9th August 2012

Application for Planning Permission for Works or Extension to a Dwelling

Development Dormer window & velux roof light to front elevation

Location 19 Old Point Middleton-on-Sea Bognor Regis

GROUND FLOOR PLAN 1:50

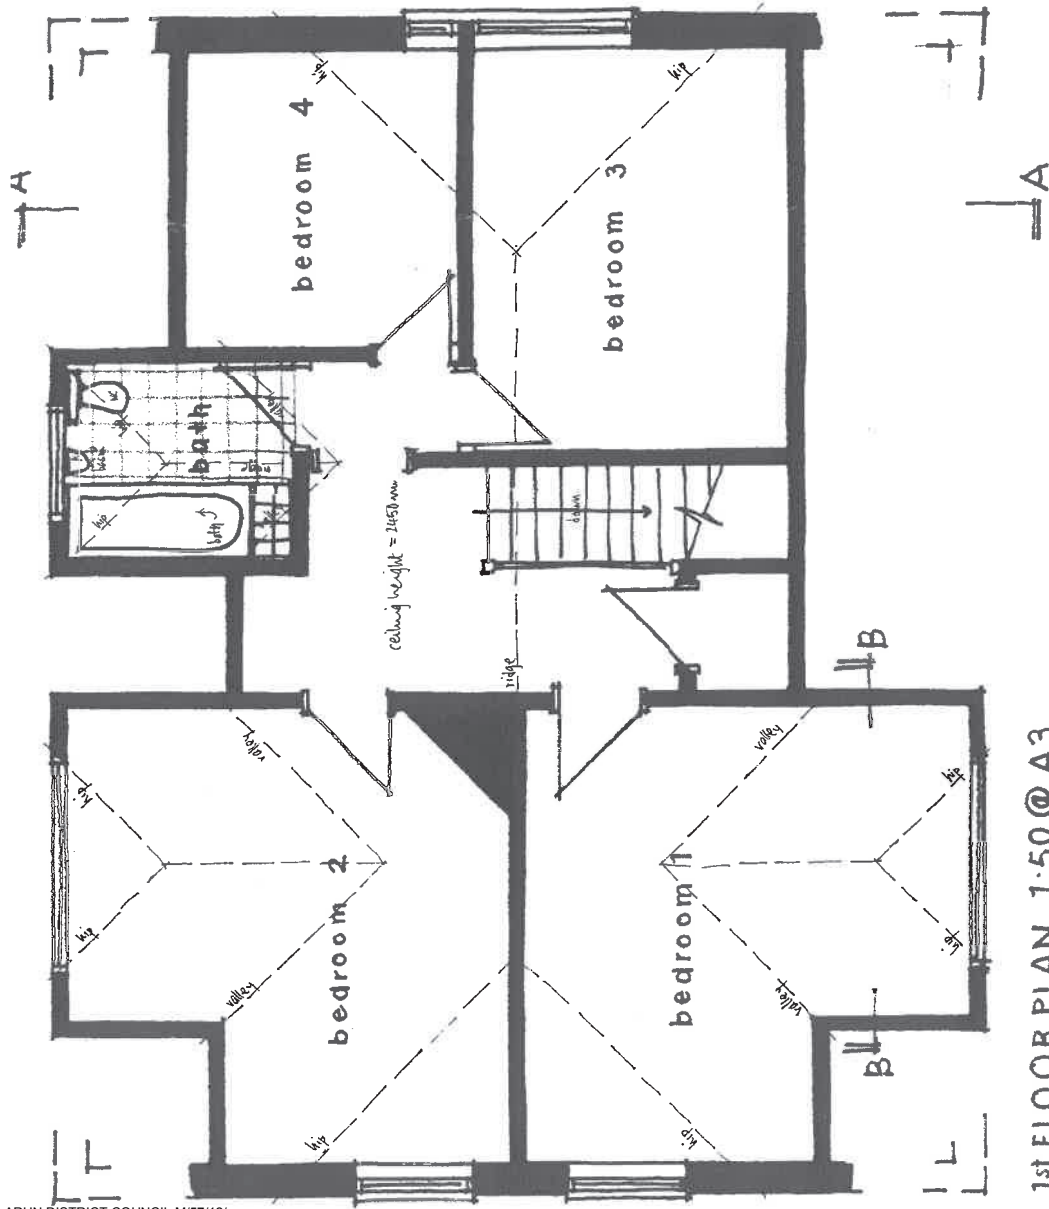
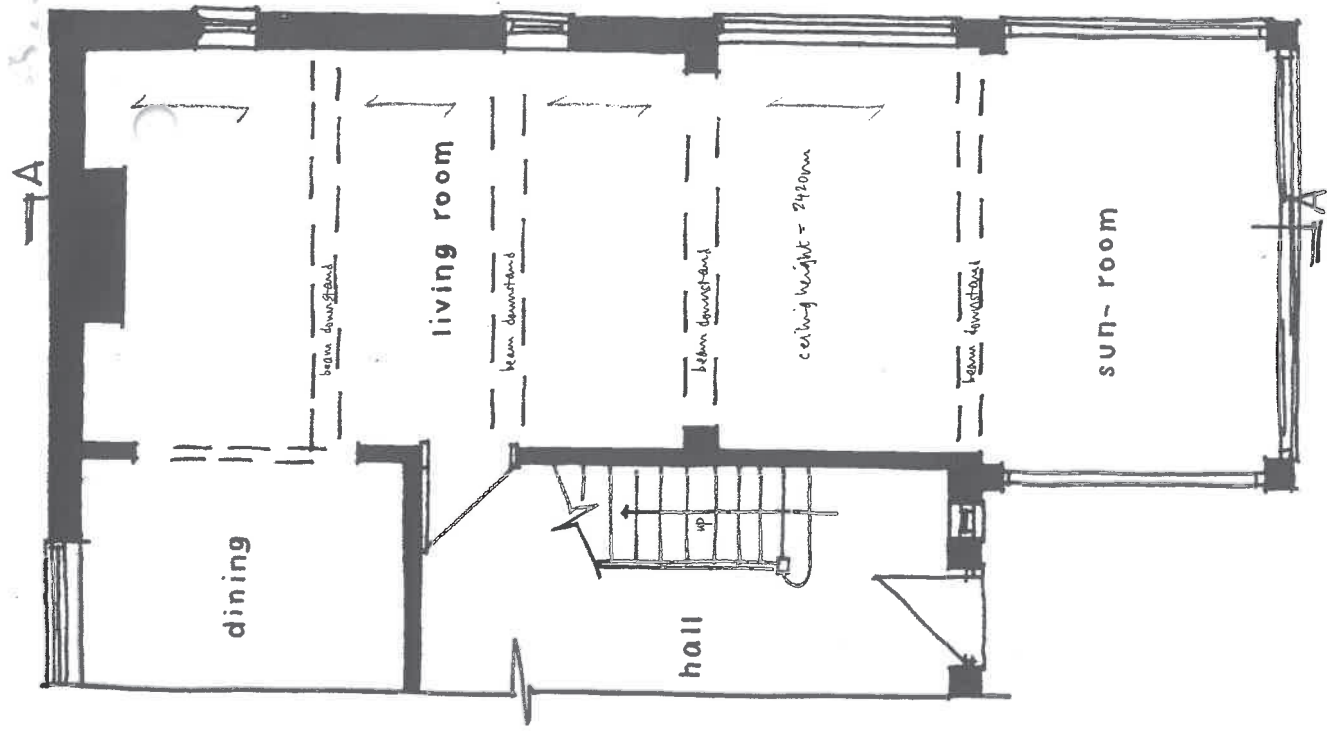
Please provide 1 electronic or 3 paper copies of a revised existing ground floor plan. There is a window shown on the existing side elevation (next to sun room) which is not on the floor plan.

SITE PLAN 1:500 @ A4

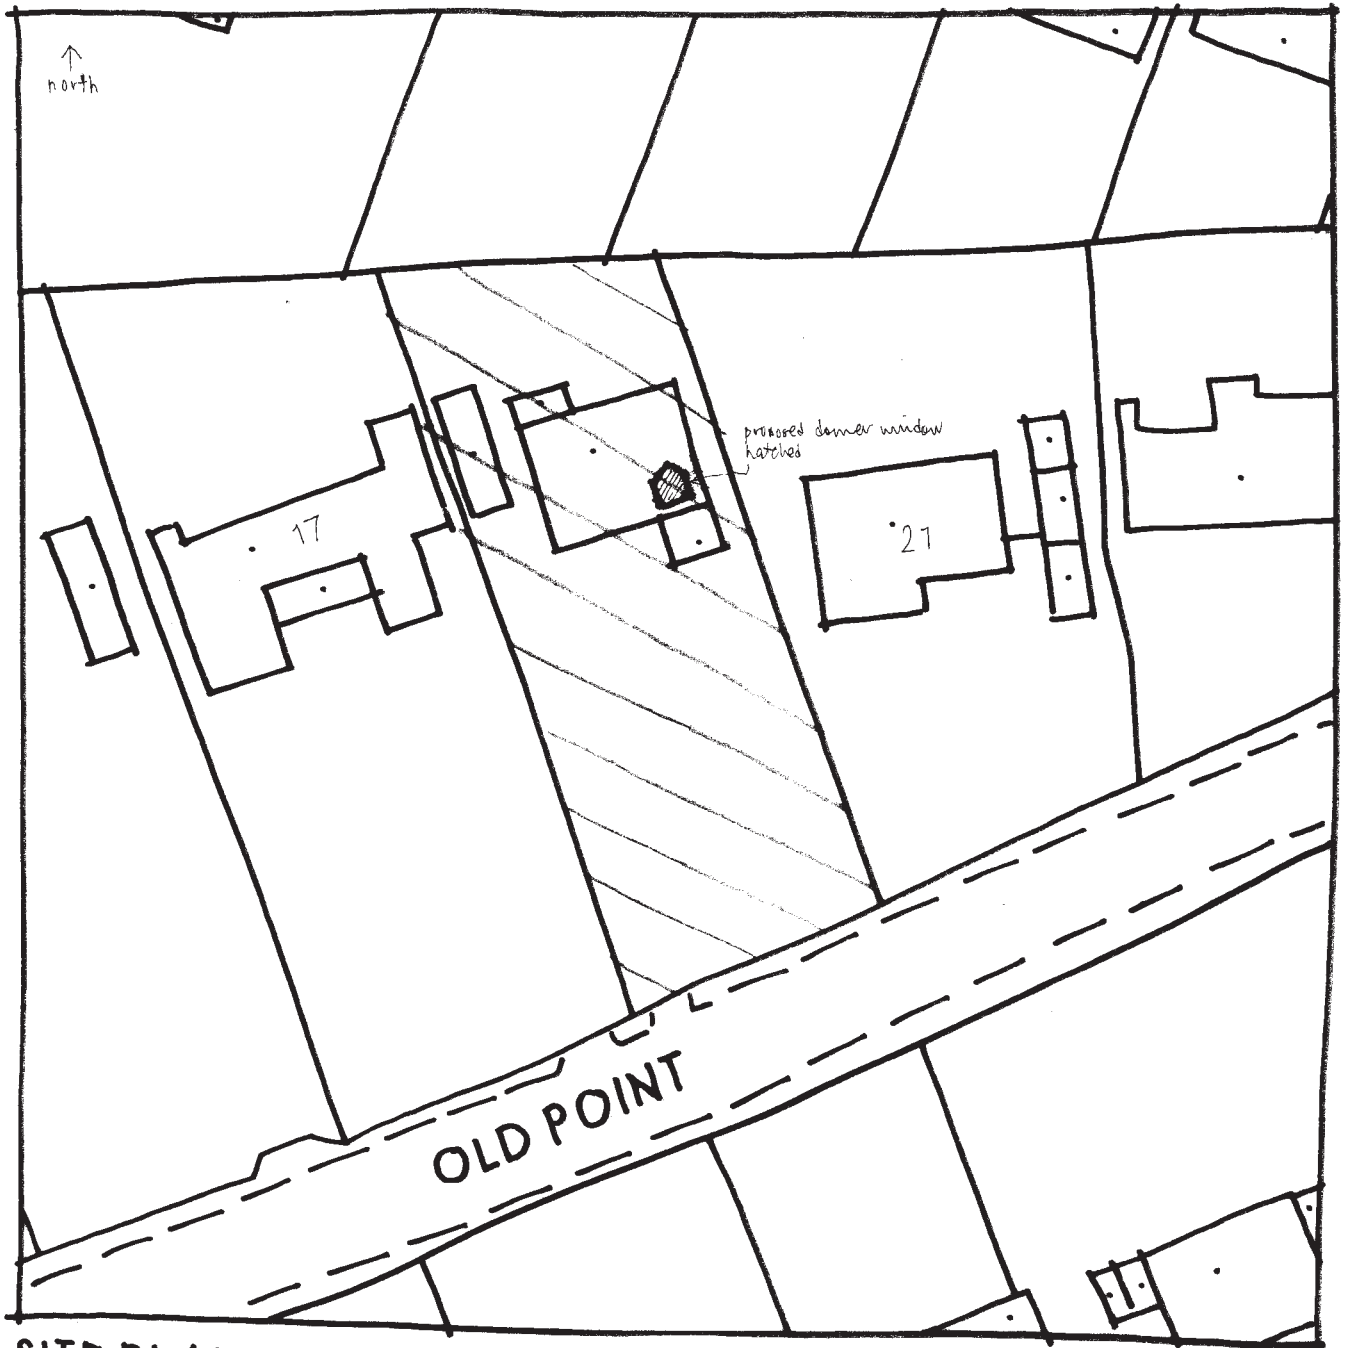
I require 1 electronic or 3 paper copies of a revised location plan showing a red edge around the application site and Old Point marked as a named road. ✓

PROPOSED ELEVATIONS 1:100 @ A3

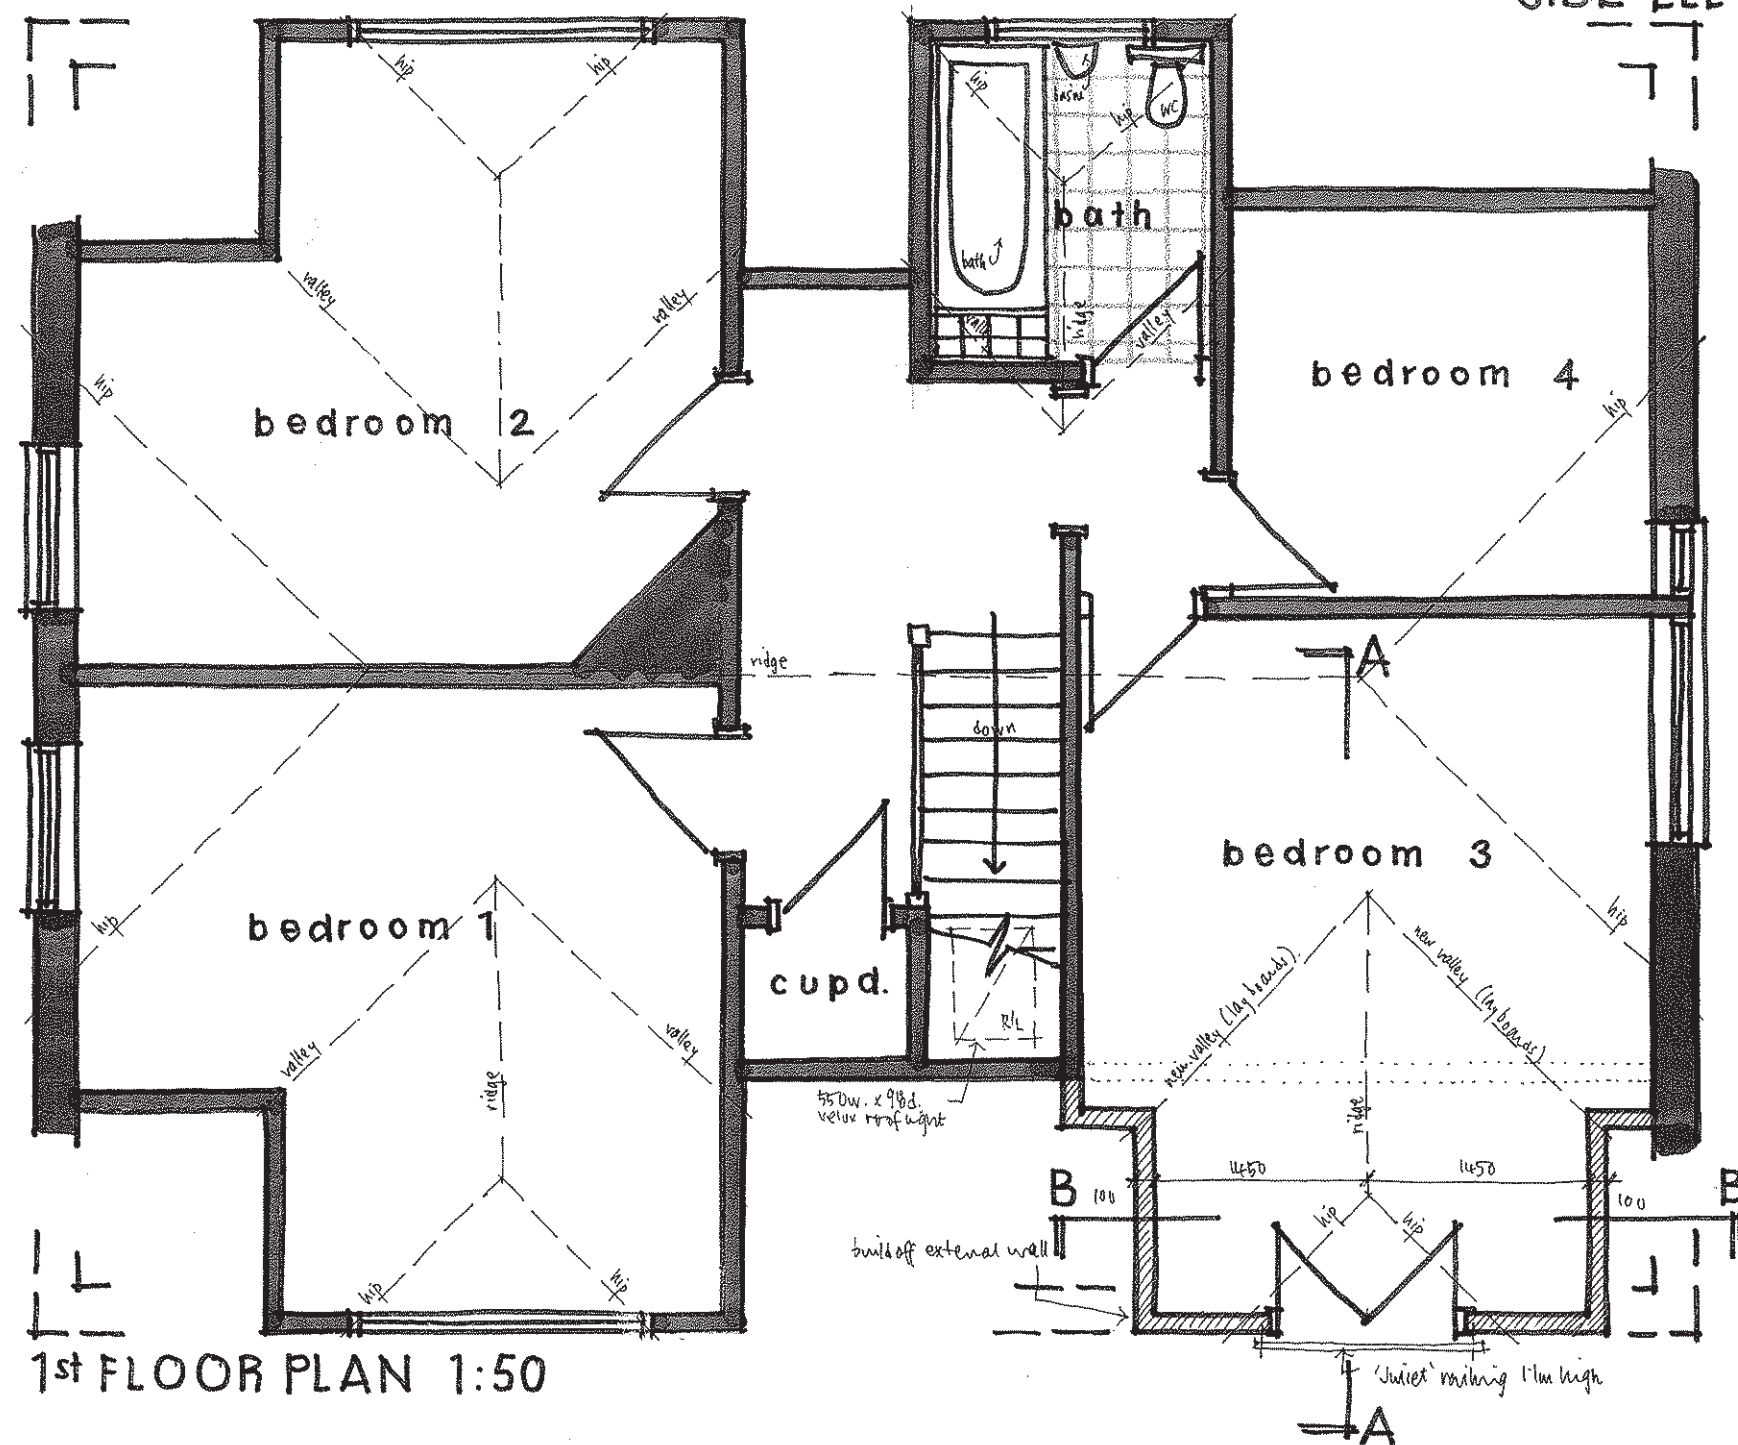
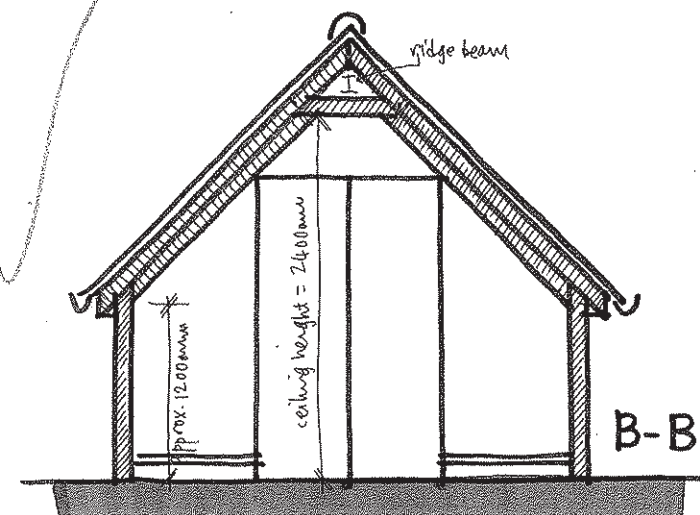
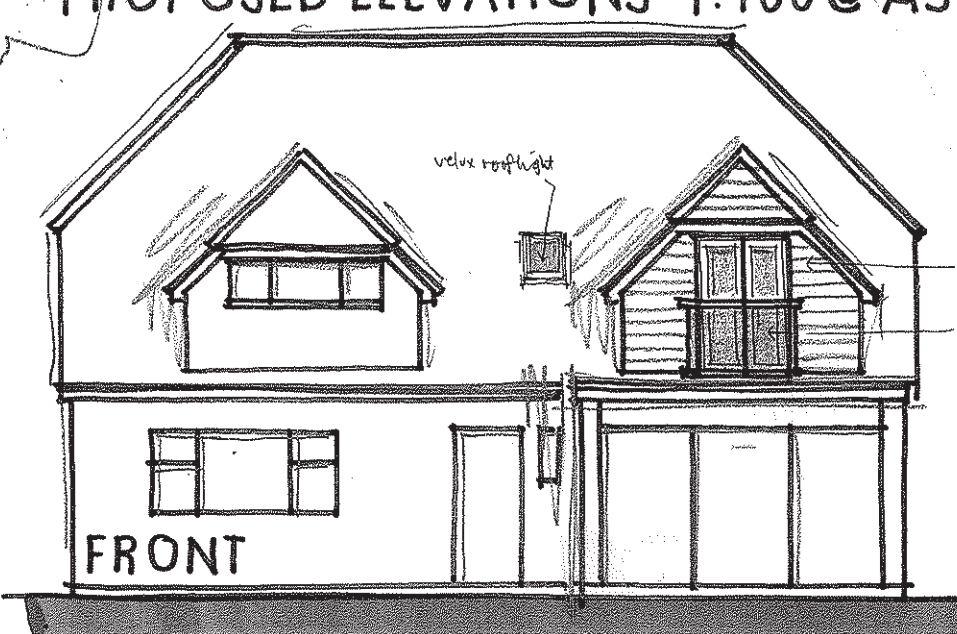
Please provide 1 electronic or 3 paper copies of the other proposed side elevation.
